Subdivision Comments

To: Chace Pedersen, CDS Planner I
From: Holly Erdman, B.S., Environmental Health Specialist II
Date: 8/2/23
RE: SP-23-00005 Craig

SWEETWATER SHORT PLAT
PART OF SECTION 29, T. 19 N., R. 19 E., W.M.
KITTITAS COUNTY, WASHINGTON

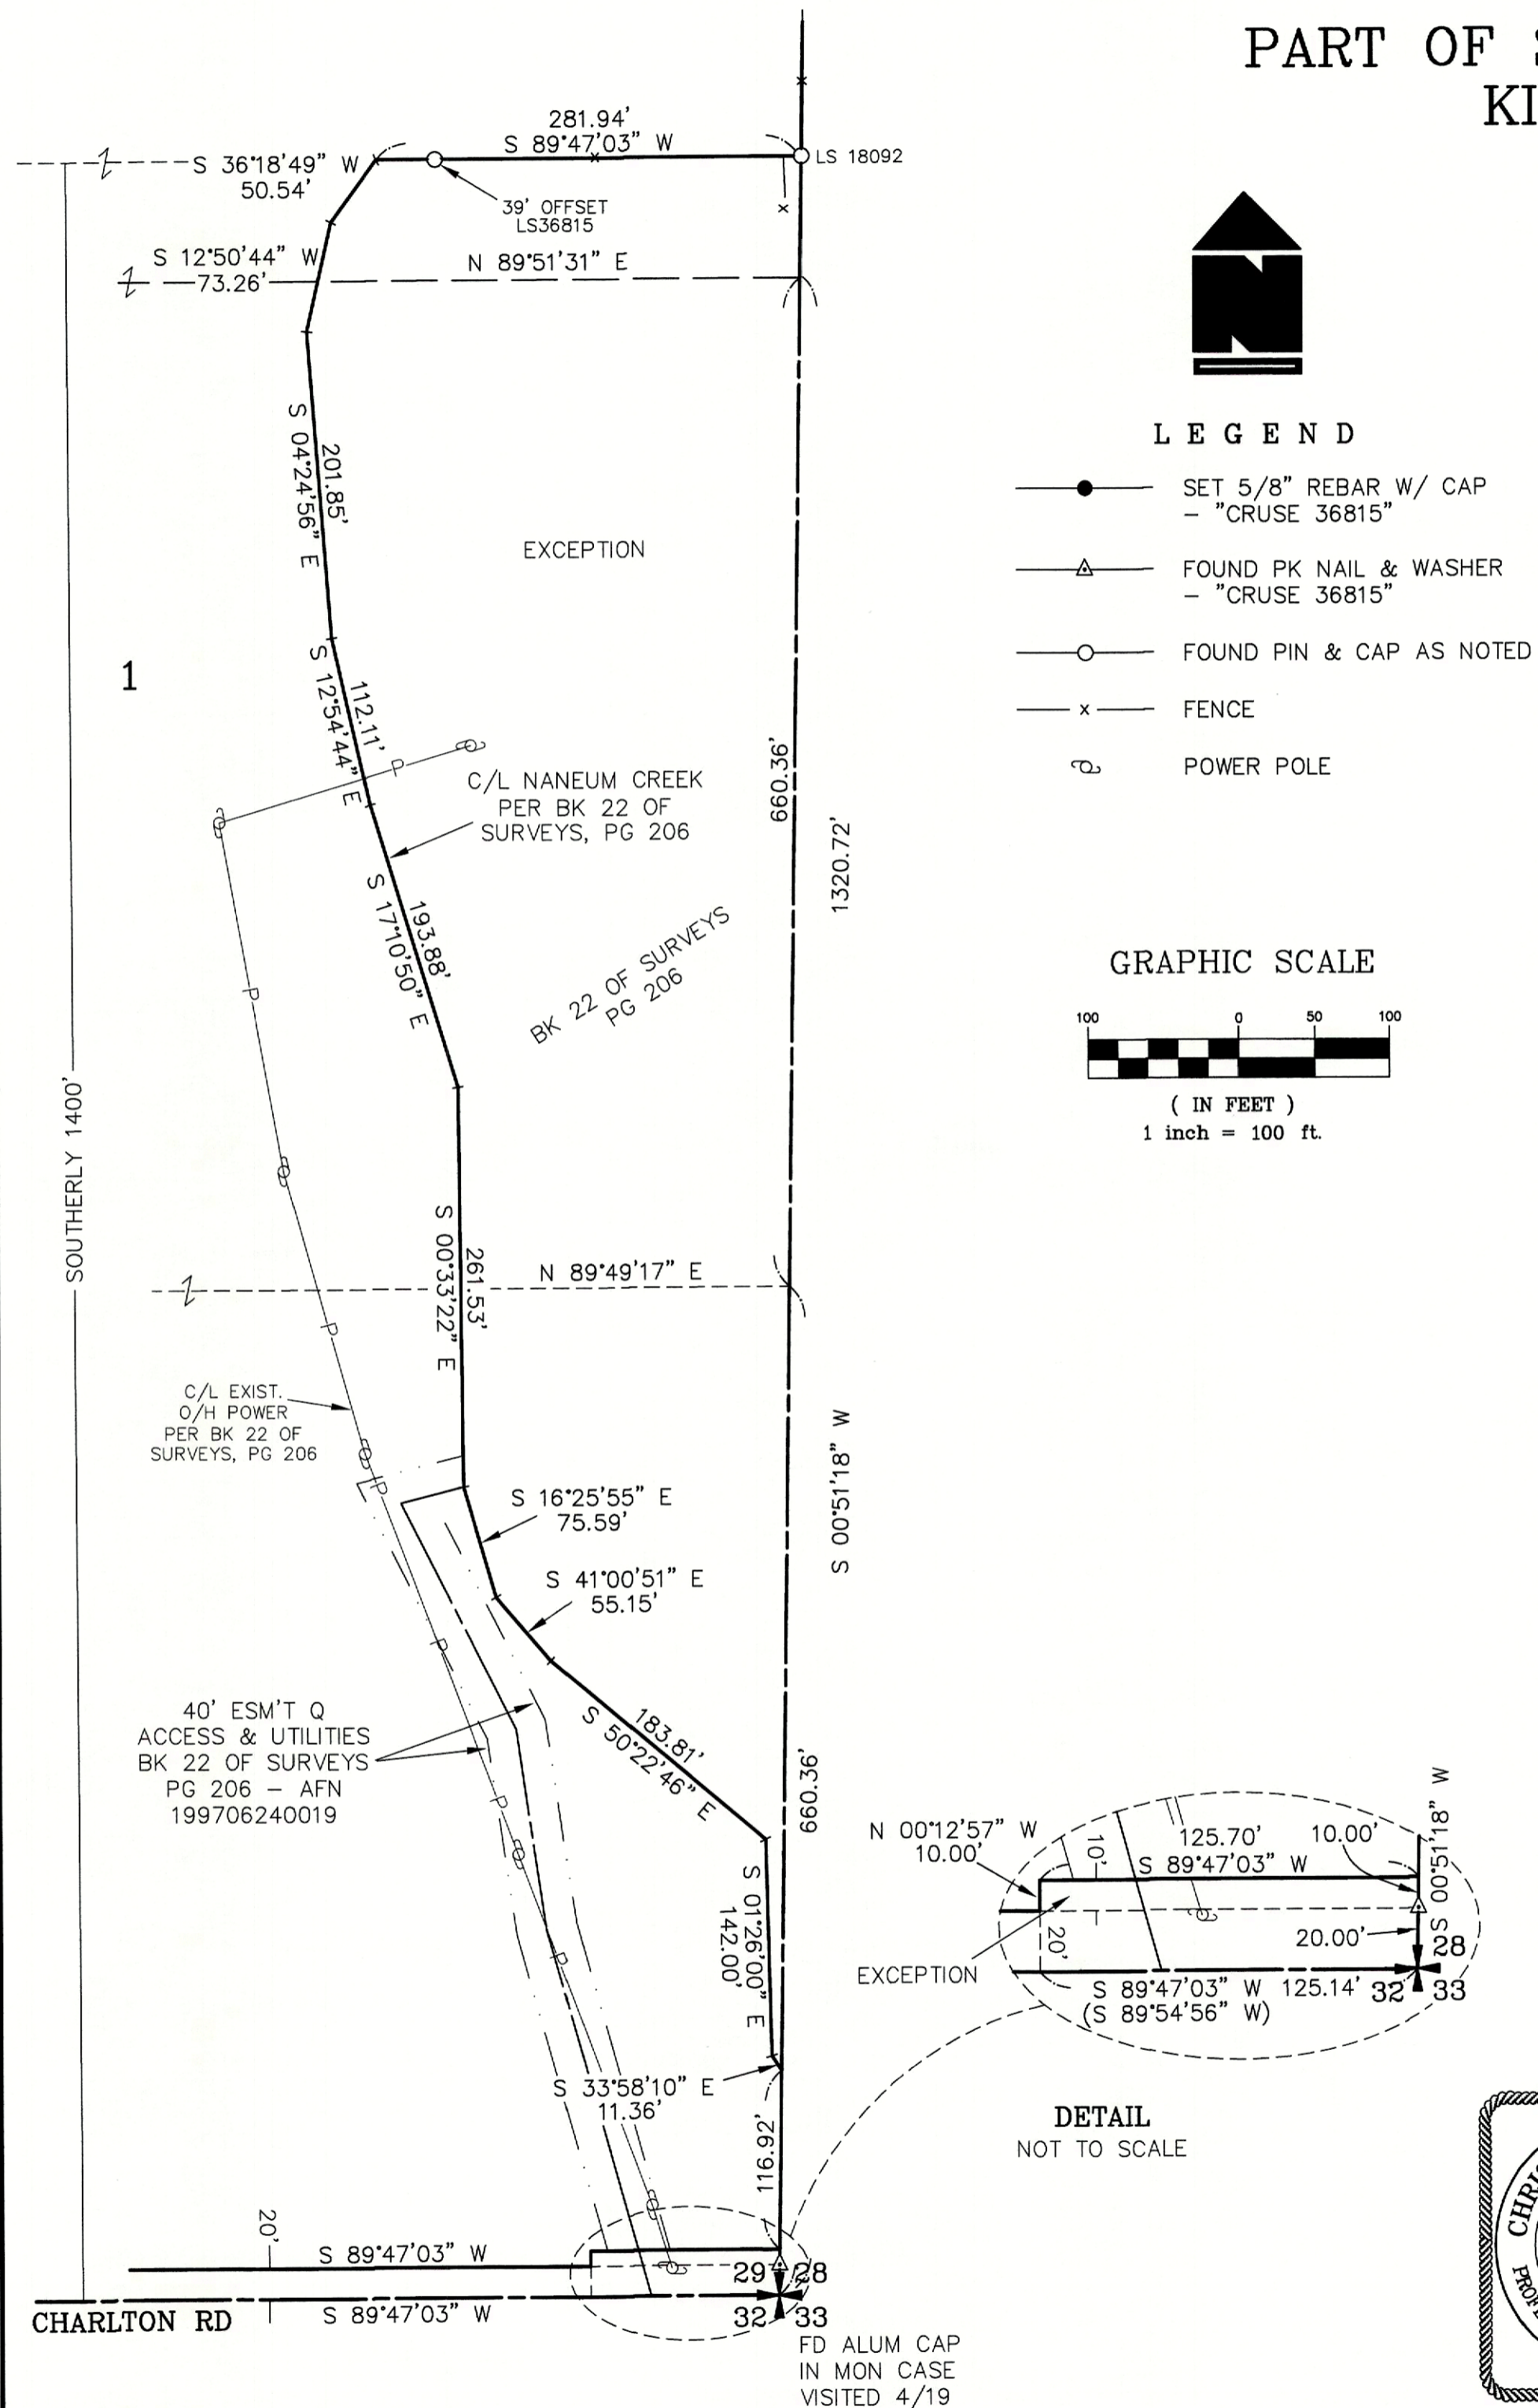
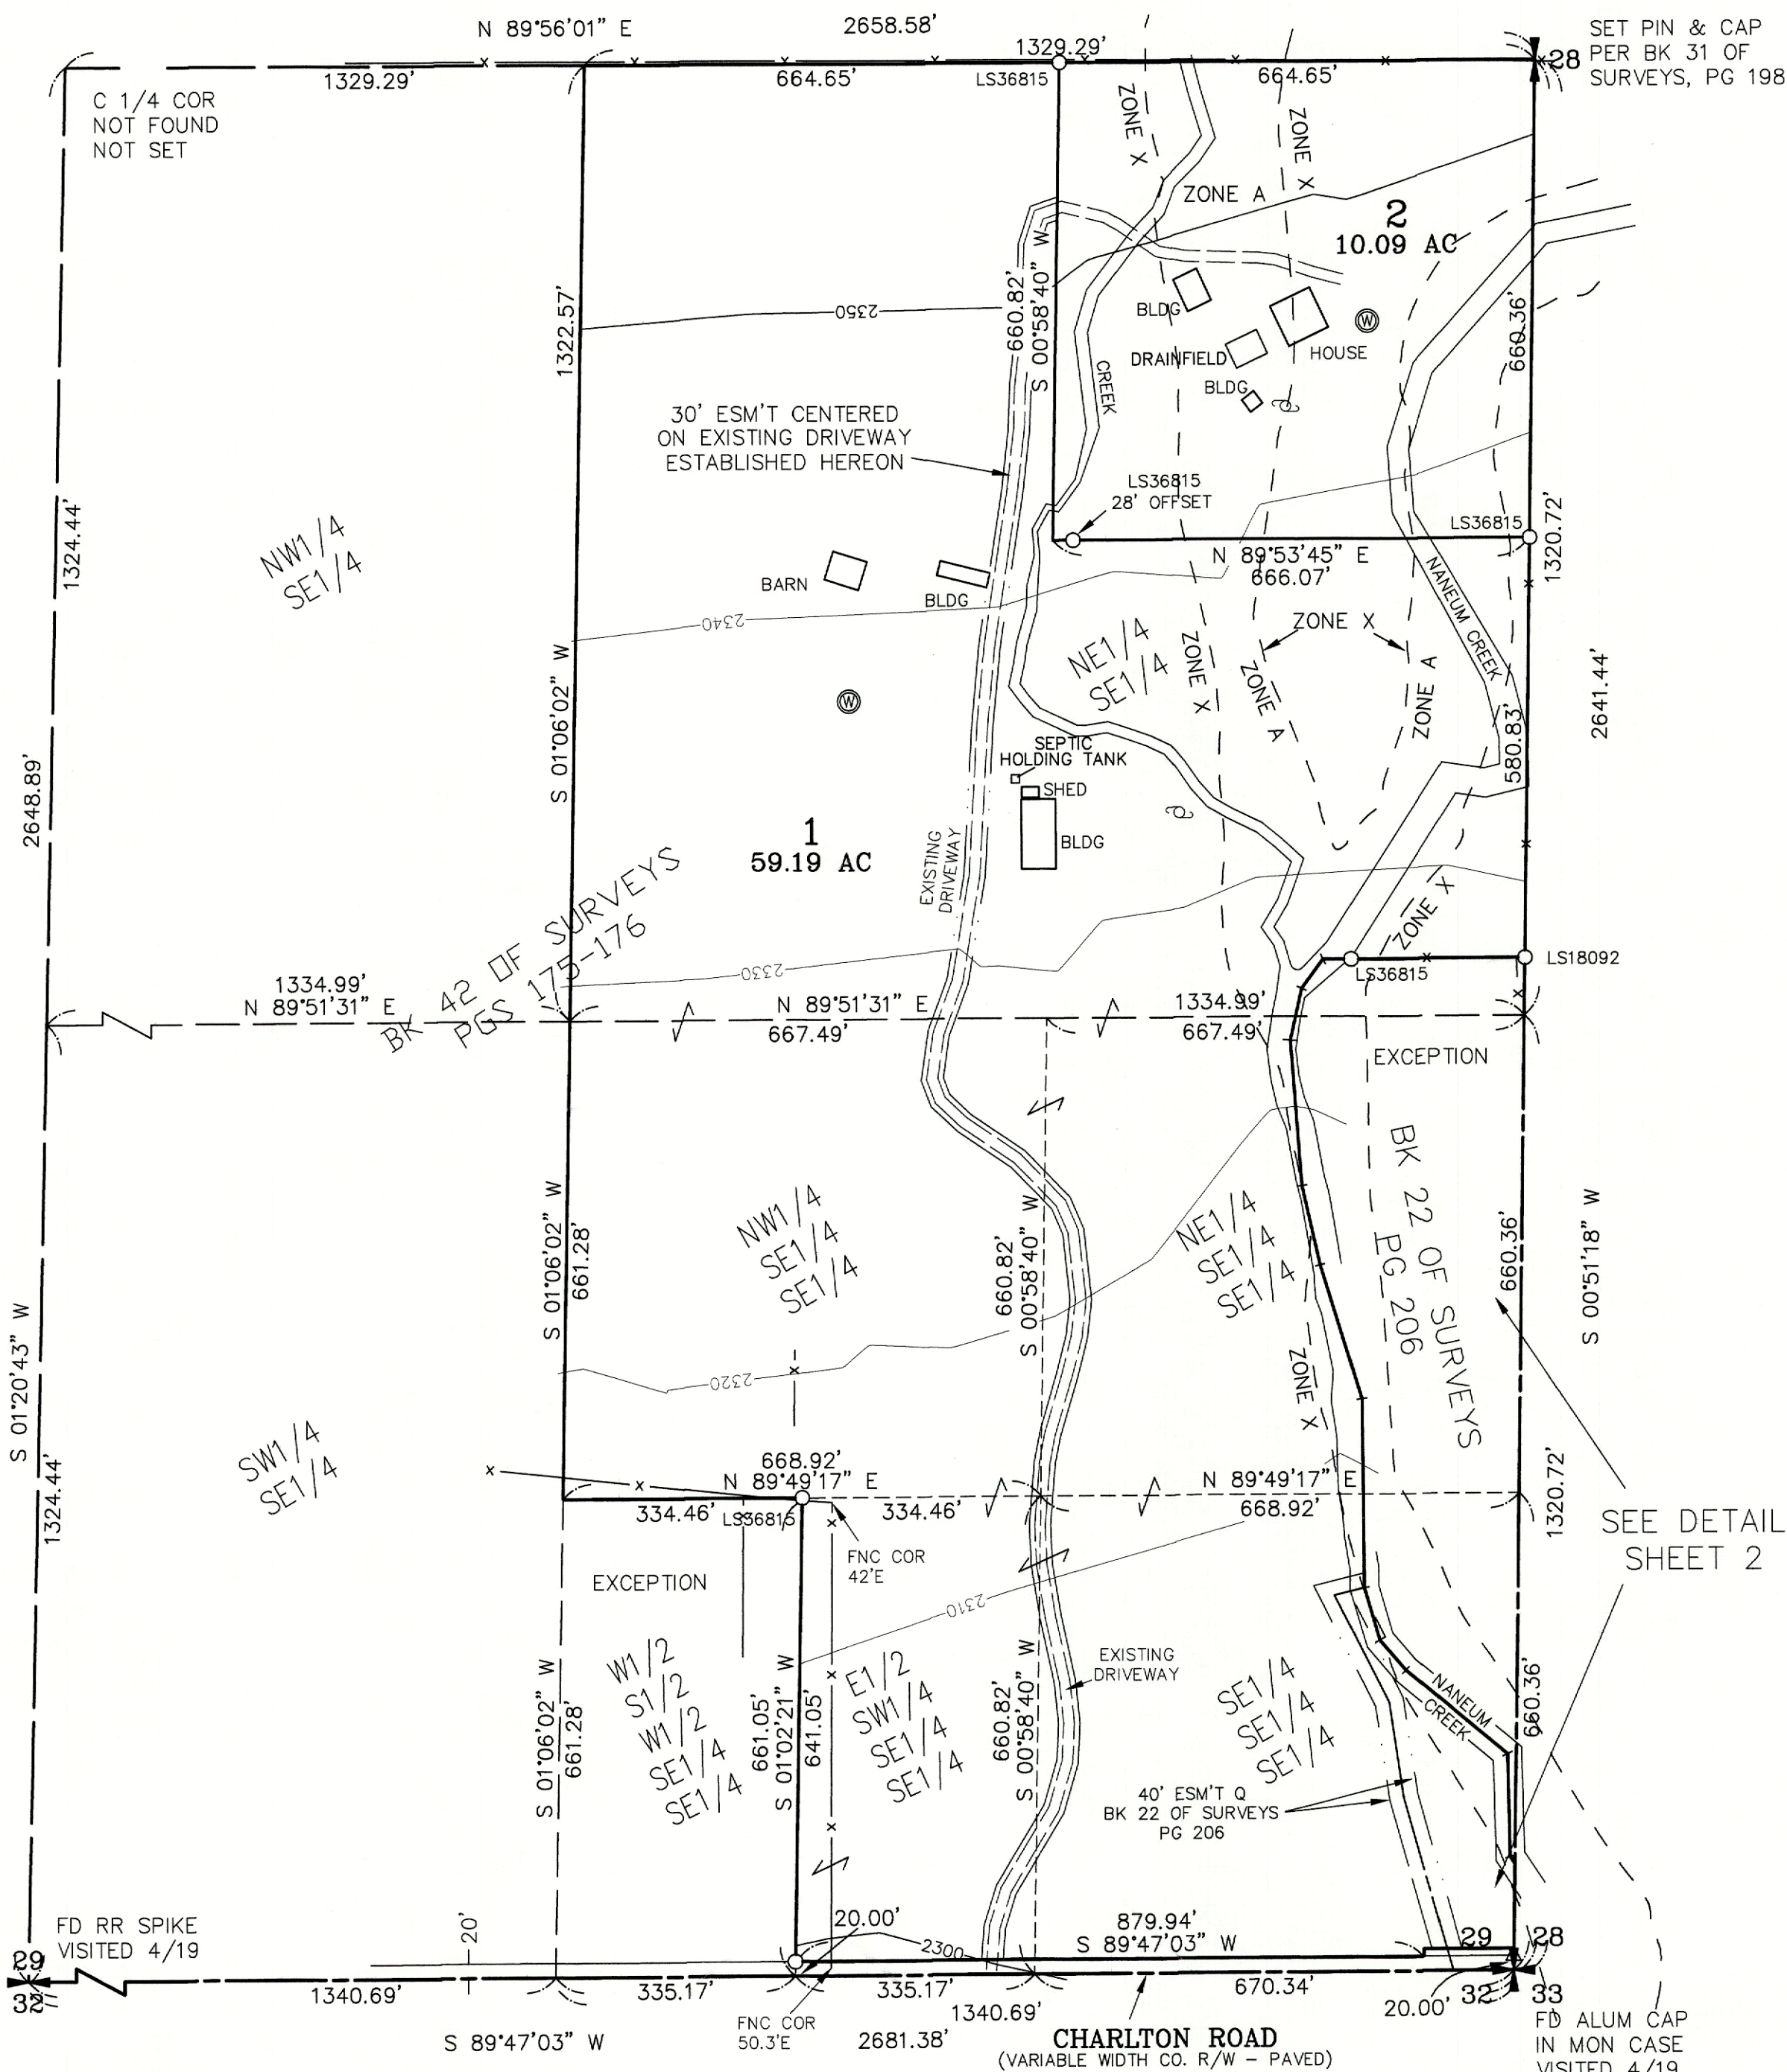
The proposed short plat drawing indicates there is an existing well on each proposed lot. The applicant indicates there will be an individual well and septic system on each lot. The applicant must prove legal and physical availability of water for all new uses of water on proposed lots.

A well log for the existing well on lot 1 must be submitted for review. Water rights are needed for lot 1.
